APPENDIX A – Response to Government Agencies and Organisations

State Significant Development SSDA 8669

St Aloysius' College

1 North Elevation - Upper Pitt Street
Scale: 1:200

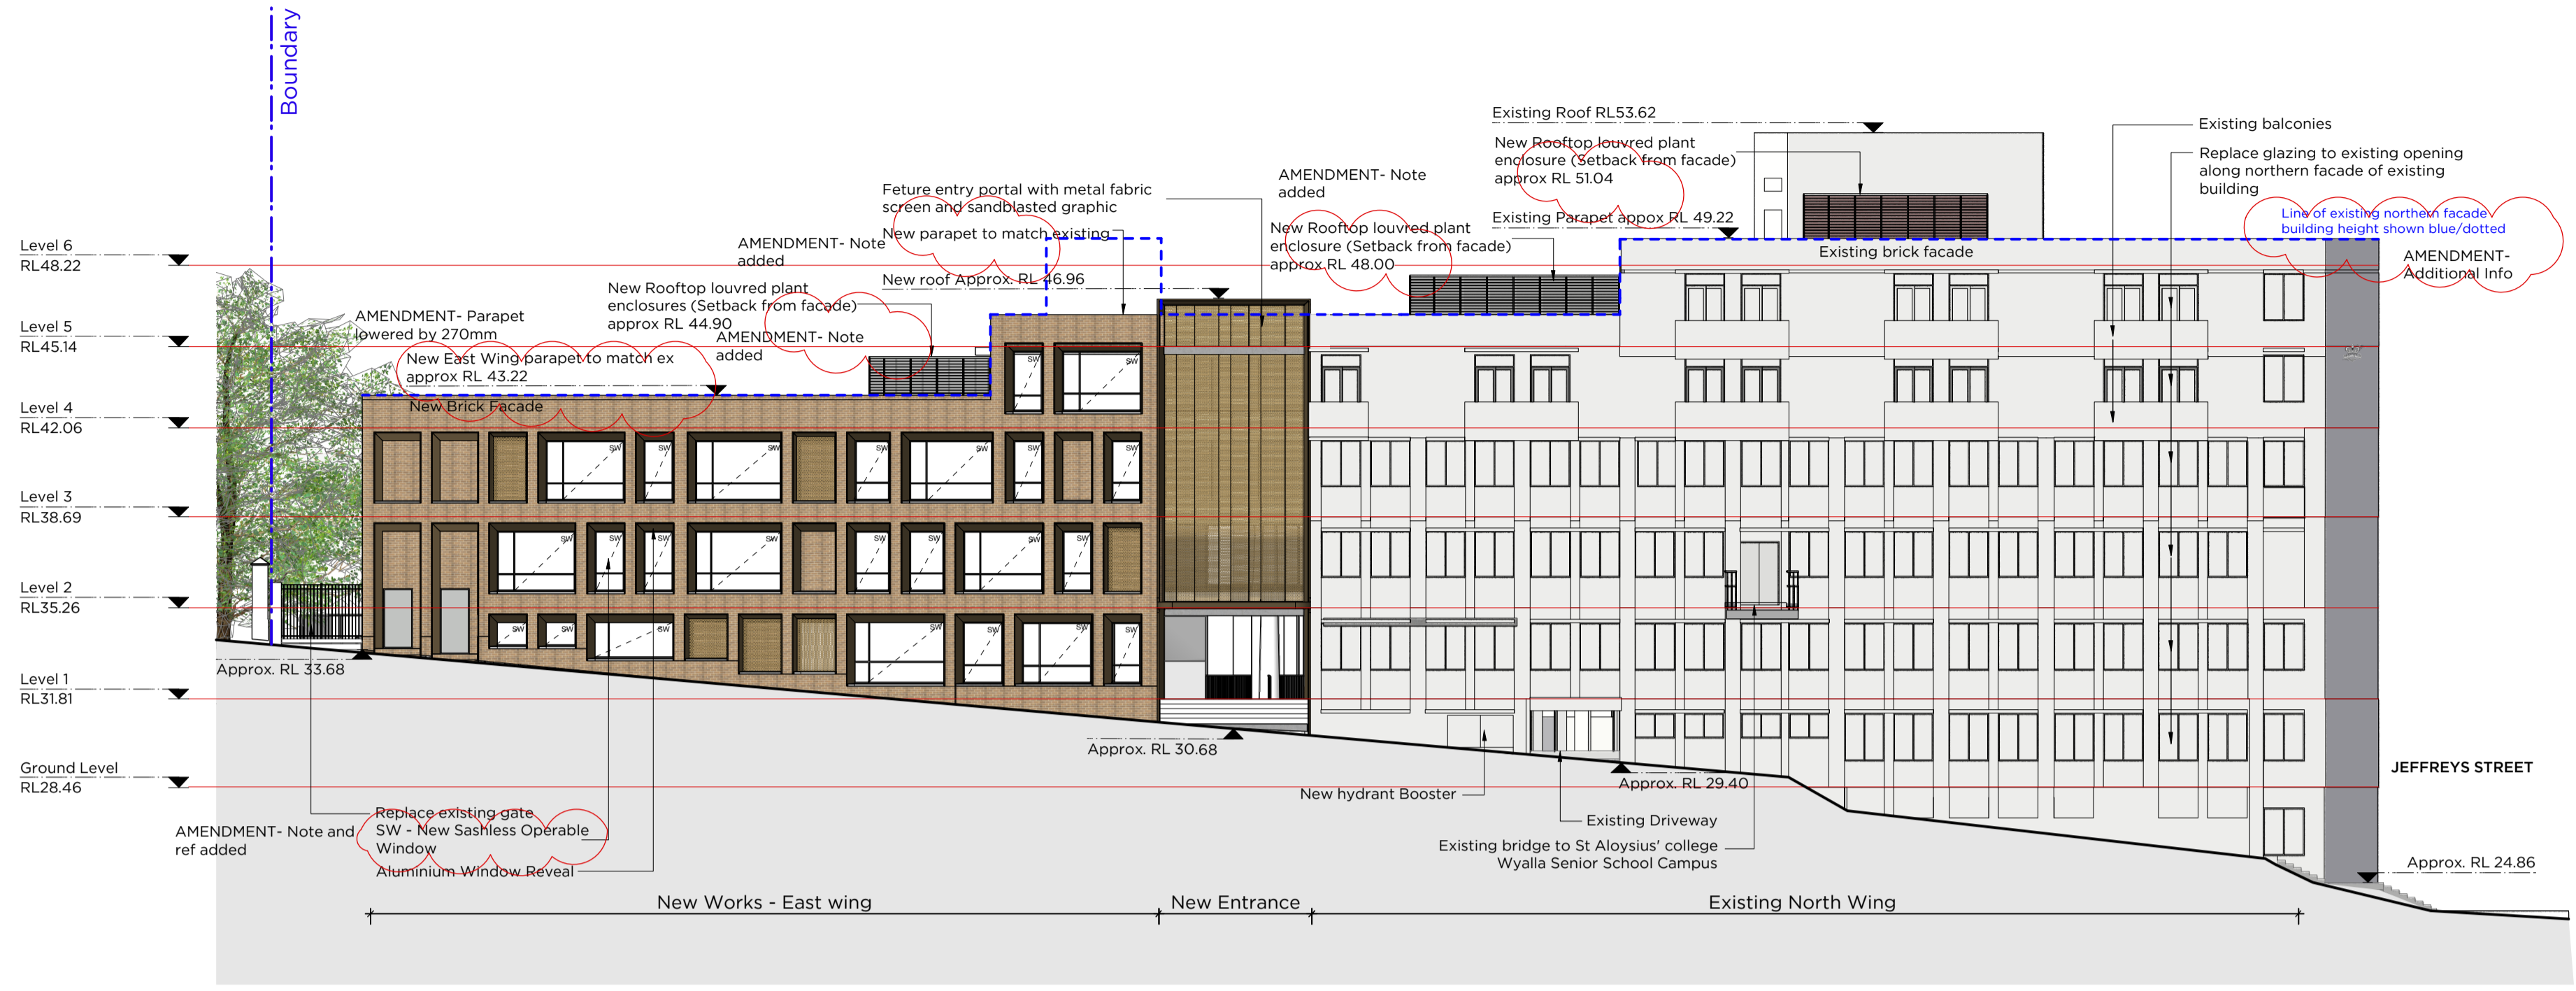
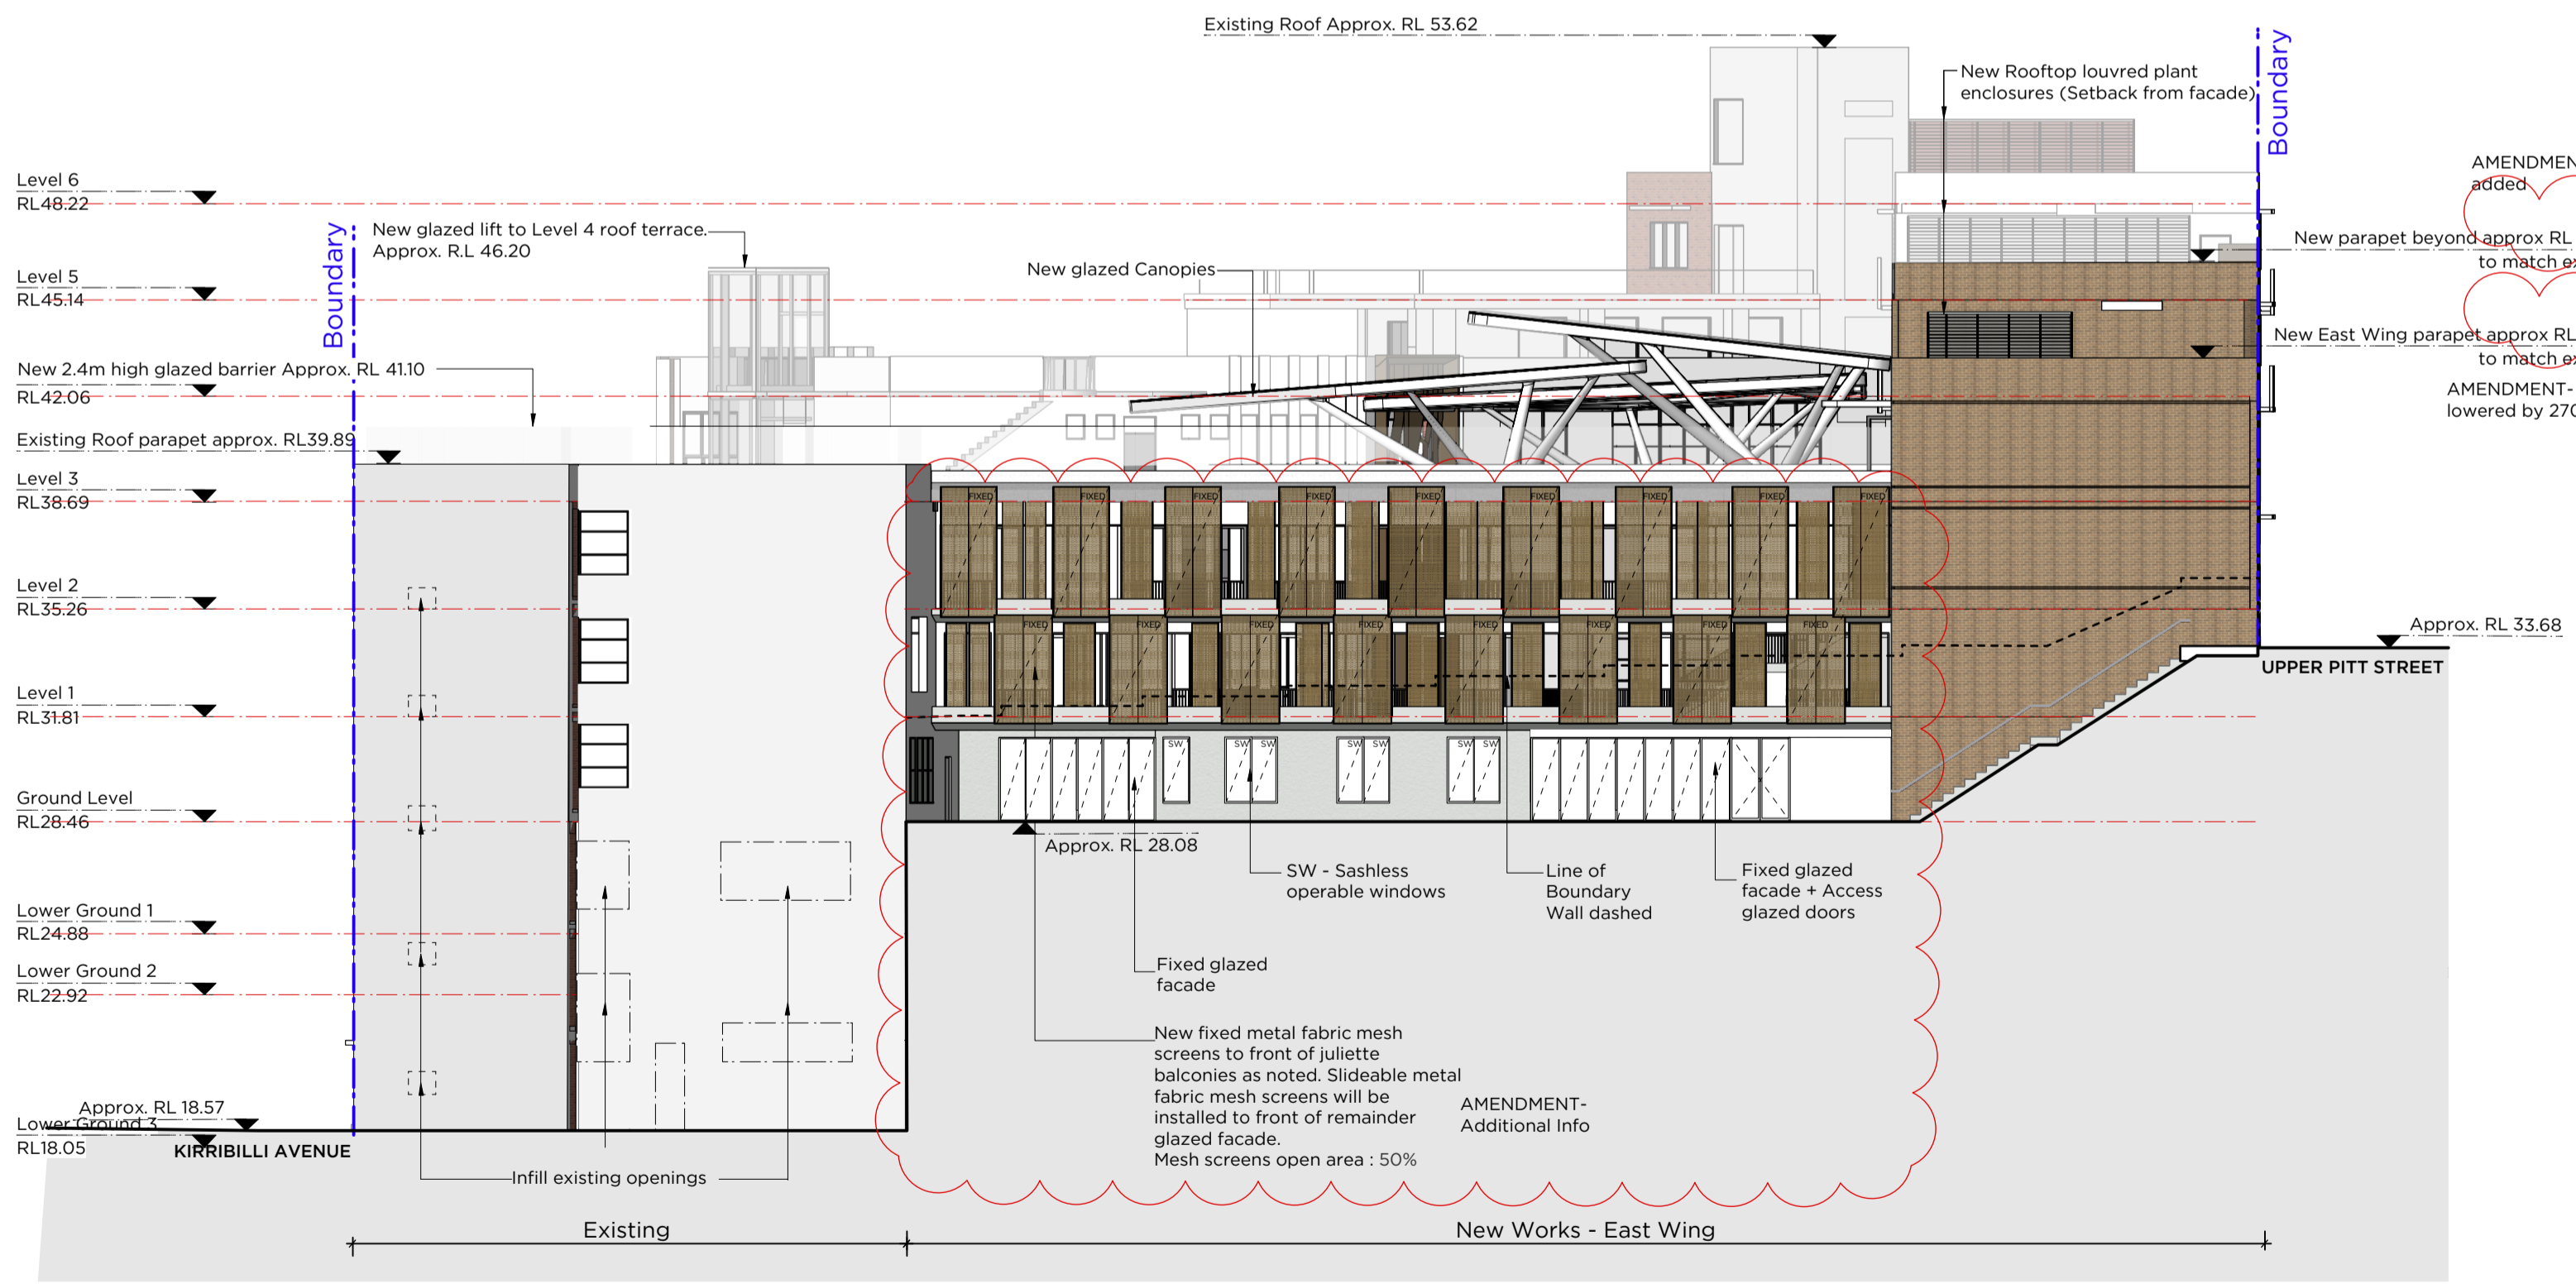
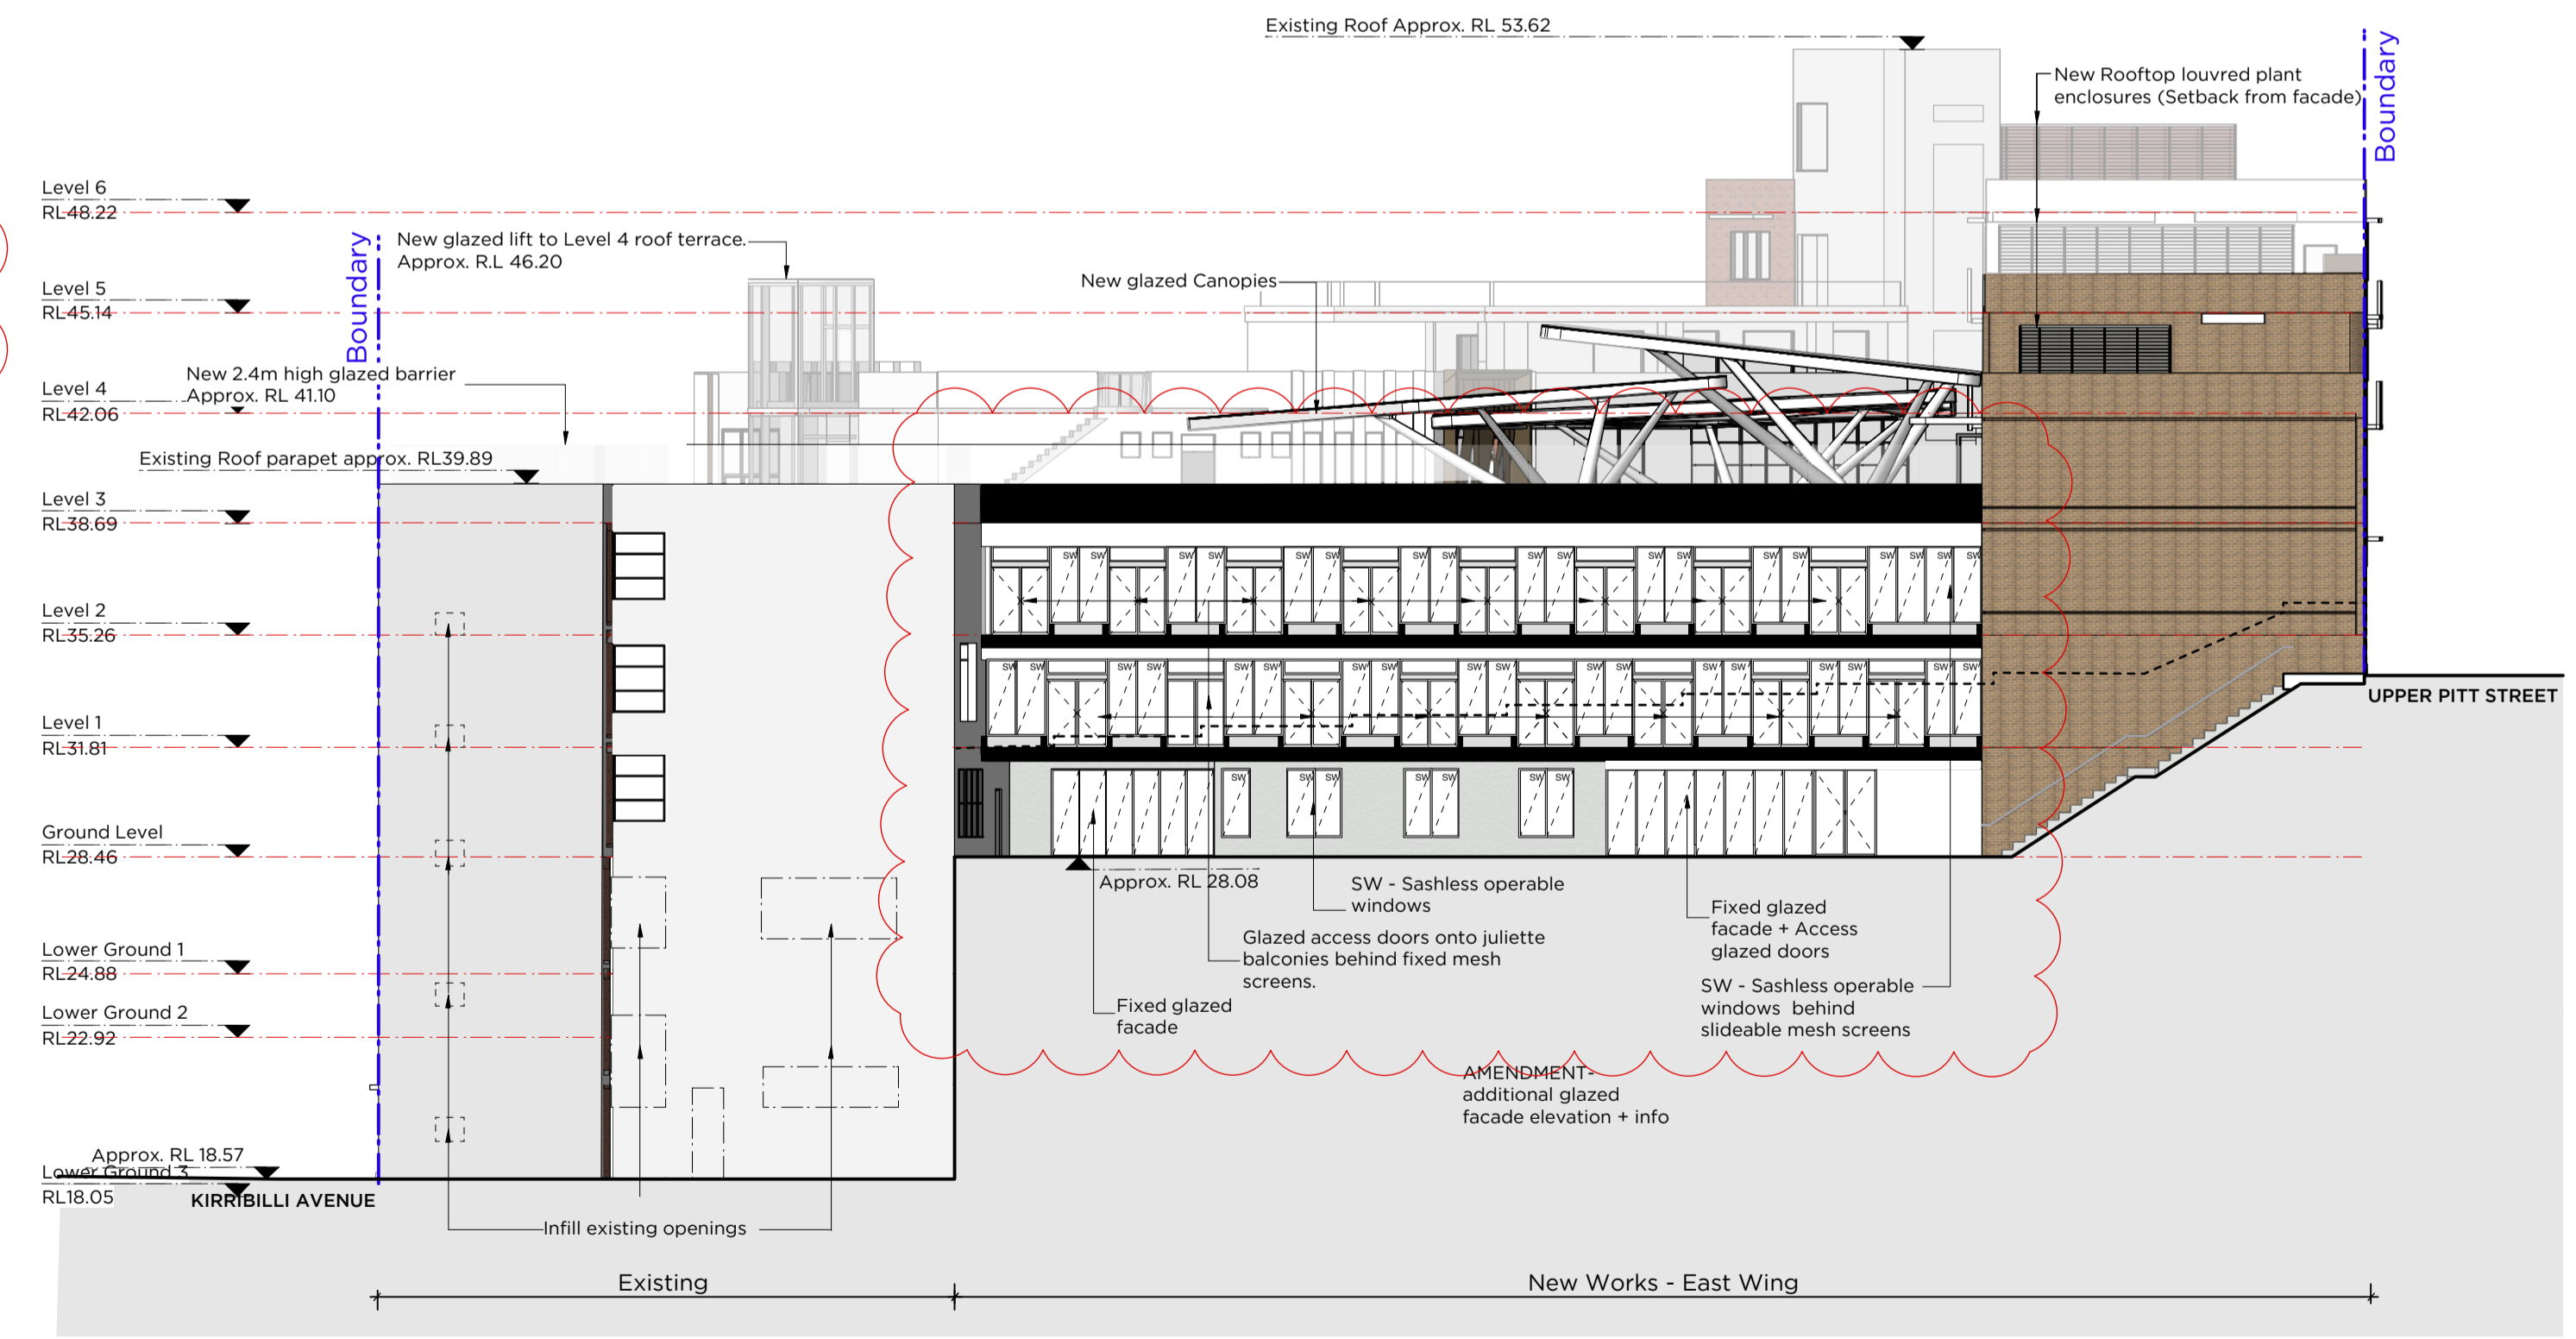
ISSUES RAISED BY AGENCIES AND ORGANISATIONS	PROPONENT'S RESPONSE
Provide more detailed northern and eastern elevations of the proposed development on the Main Campus. These should be more clearly detailed: ▪ The height of the proposed building (and associated permanent structures such as plant enclosures) in the context of the height of the existing building; and ▪ The treatment of the building facades, including the various building elements, materials to be used, the level of opacity of proposed screens, and whether fixed or openable glazing/screens are to be used.	Detailed northern and eastern elevations have been prepared by PMDL (refer to drawings DAU302 and DAU303). In addition, DA202 (revision E) clearly indicates the existing building height, in comparison to the proposed built from fronting Upper Pitt Street.
Confirmation must be provided that the VIA and Solar Impact Analysis (SIA) have had regard to the proposed landscaping of the rooftop terrace (including tree heights at maturity) and any opaque structural elements required to support the 2.4 metre high acoustic barrier around, and the protruding glazed lift shaft protruding above, the proposed roof terrace.	The accompanying Visual Impact Assessment (Appendix E) and Solar Impact Analysis (Appendix N) have carefully studied the potential impacts of the proposed rooftop terrace landscaping and glazed barriers/ lift shaft. The landscaping proposed for the rooftop terrace (maximum 3.5m from the floor) and glazed barriers will not be visible from apartment units on the 2nd and 3rd floor of 48 Upper Pitt Street. The rooftop glazed barriers are frameless with low iron glass resulting in a minimal visual impact, and will serve as a mitigation measure to reduce noise impact.
